EL PASO COUNTY
STORMWATER PERMIT FORM

Builder's Erosion and Stormwater Quality Control Permit (BESQCP)

Part III. Project Information	
Name of Subdivision and Filing <i>if not applicable, provide the Legal Description</i>	IVILO HEIGHTS SUB
Street Address	6265 Vessey Rd., Colorado Springs, CO 80908
Parcel Number	5206008005
Acreage	Total: 2.8 acres Proposed Disturbance: 1.0 acres
Schedule <i>input estimated month (or season) and year</i>	Start of Construction: October, 2026 Completion of Construction: July 2027

1 SITE PLAN
A01 1" = 20'-0"

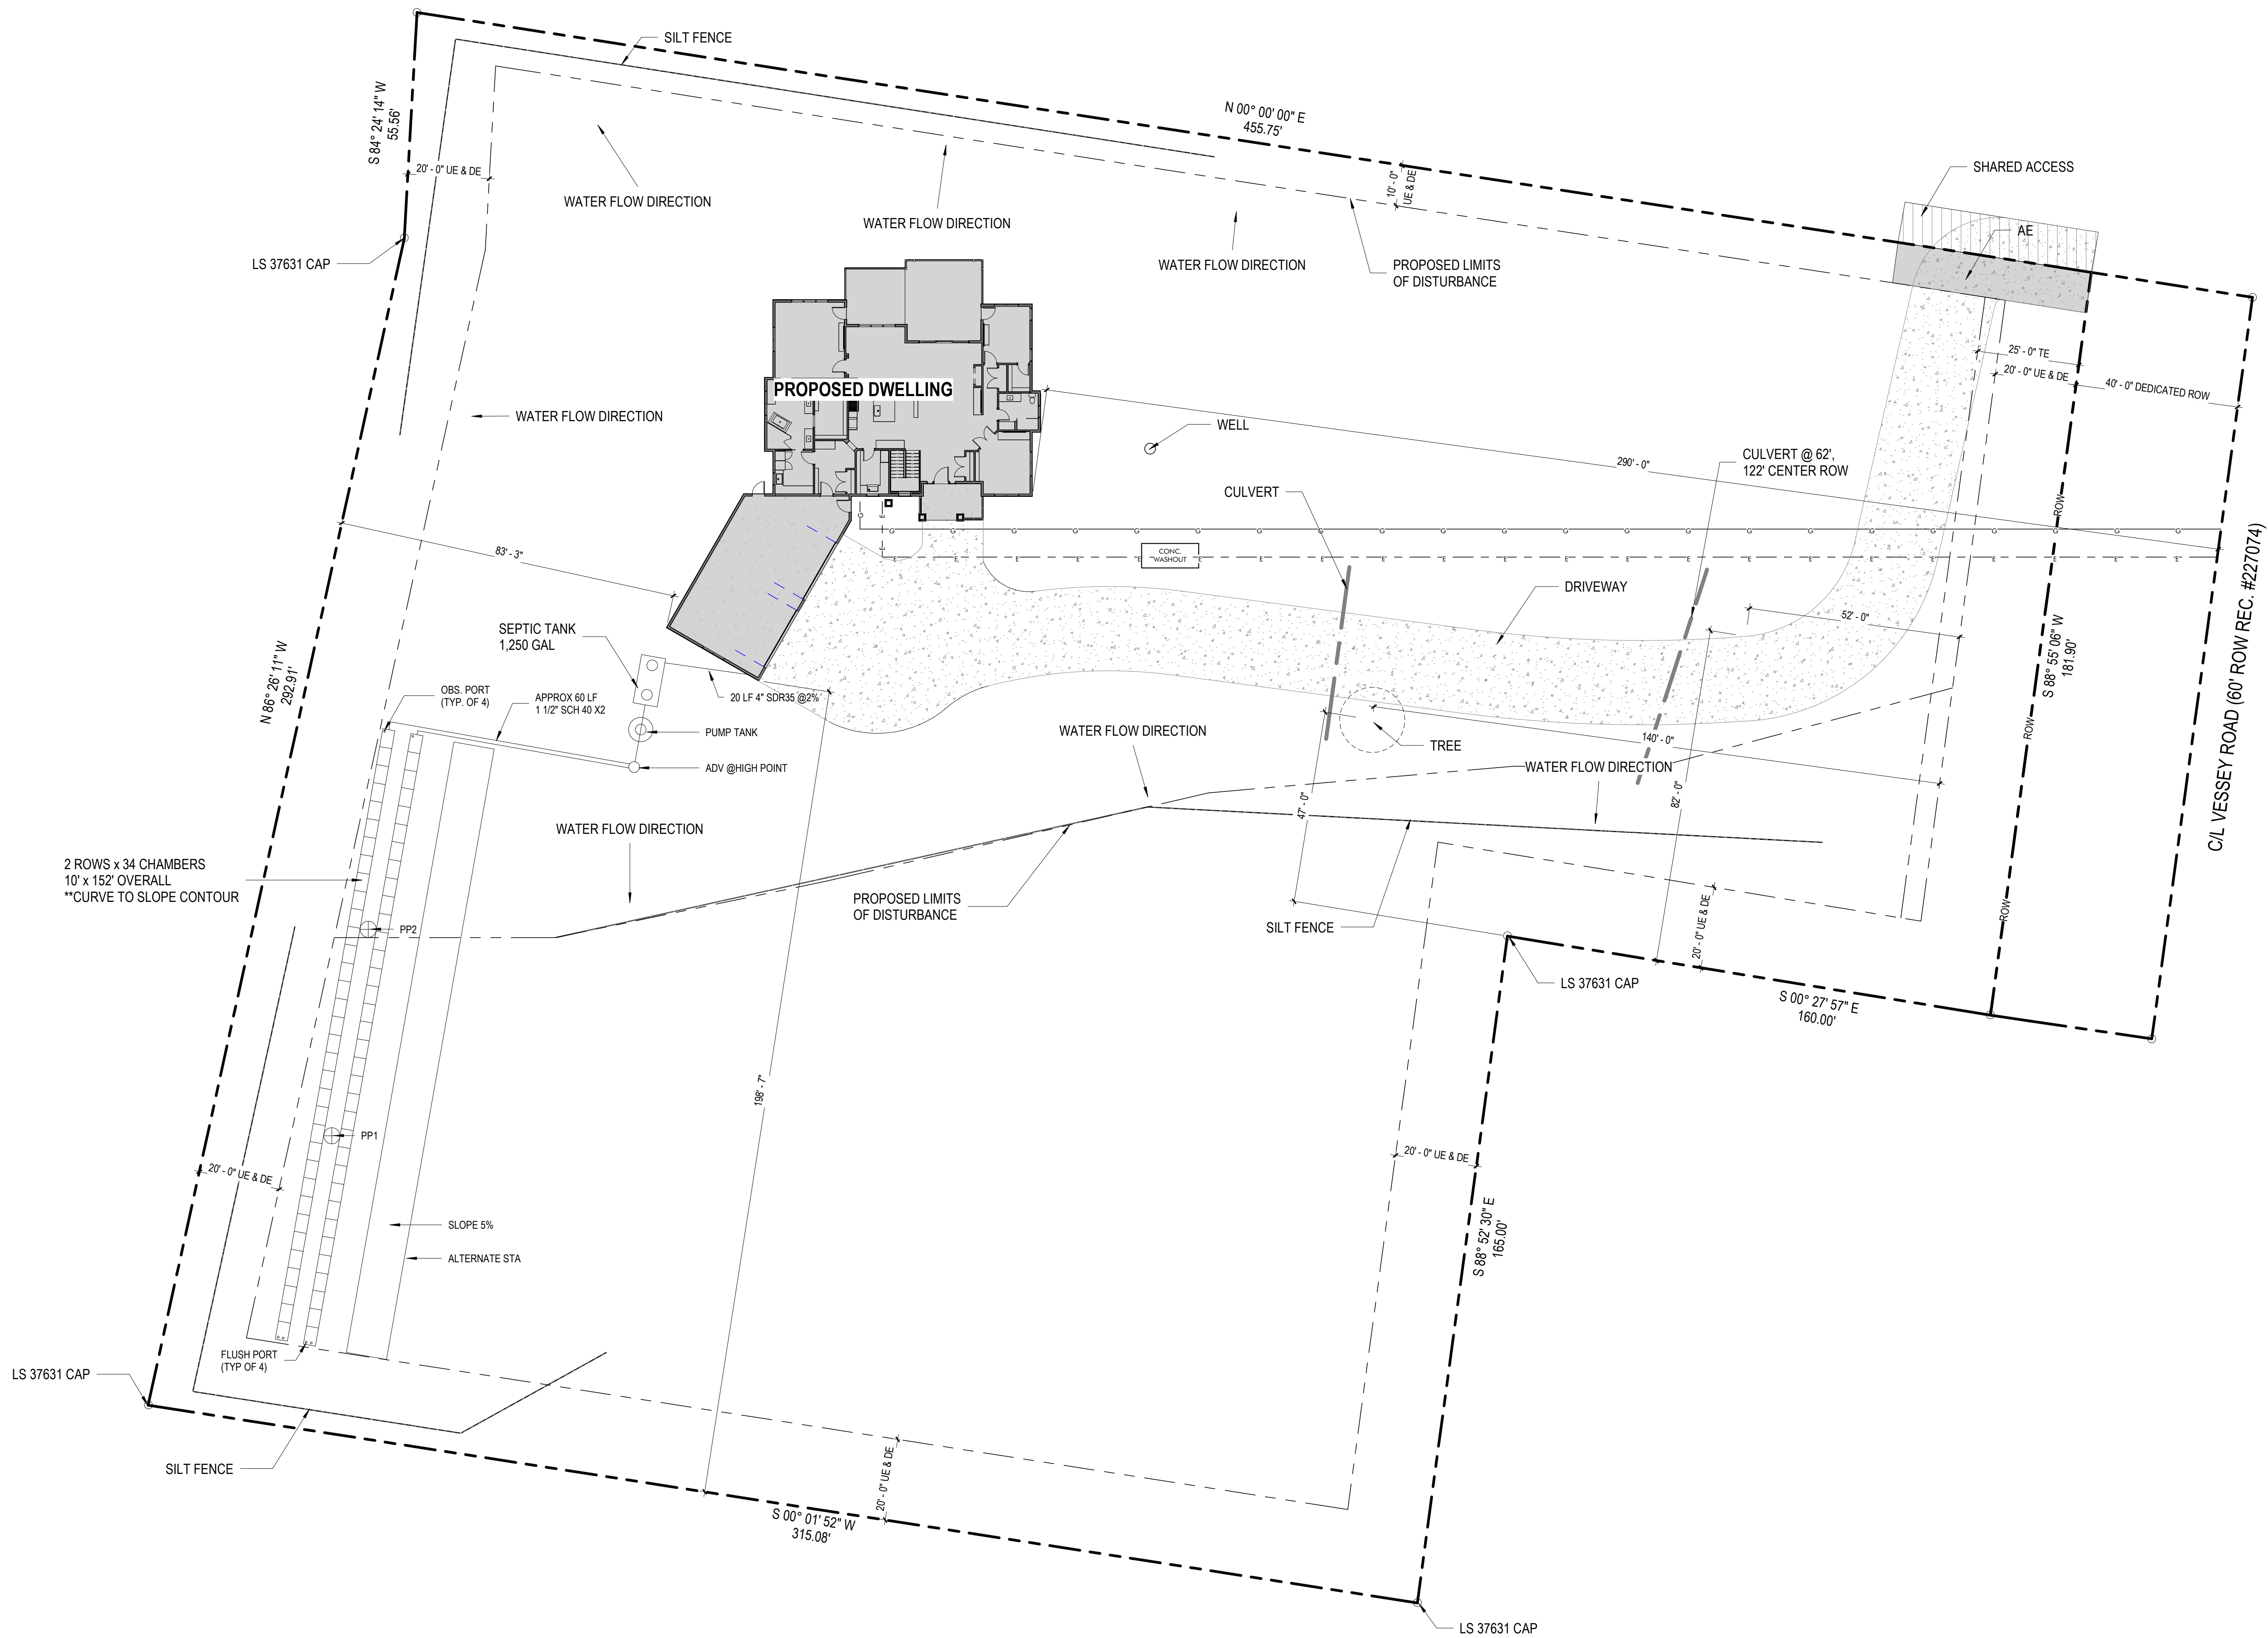
If disturbance is 1.0ac or more, an ESQCP is needed, which is an much more involved process. You will need GEC Plan, SWMP, Drainage Letter, and more. Plus there are frequent site inspections during construction. So I definitely recommend doing what you can on this sheet and the Site Map to get the proposed limits of disturbance to be <1ac.
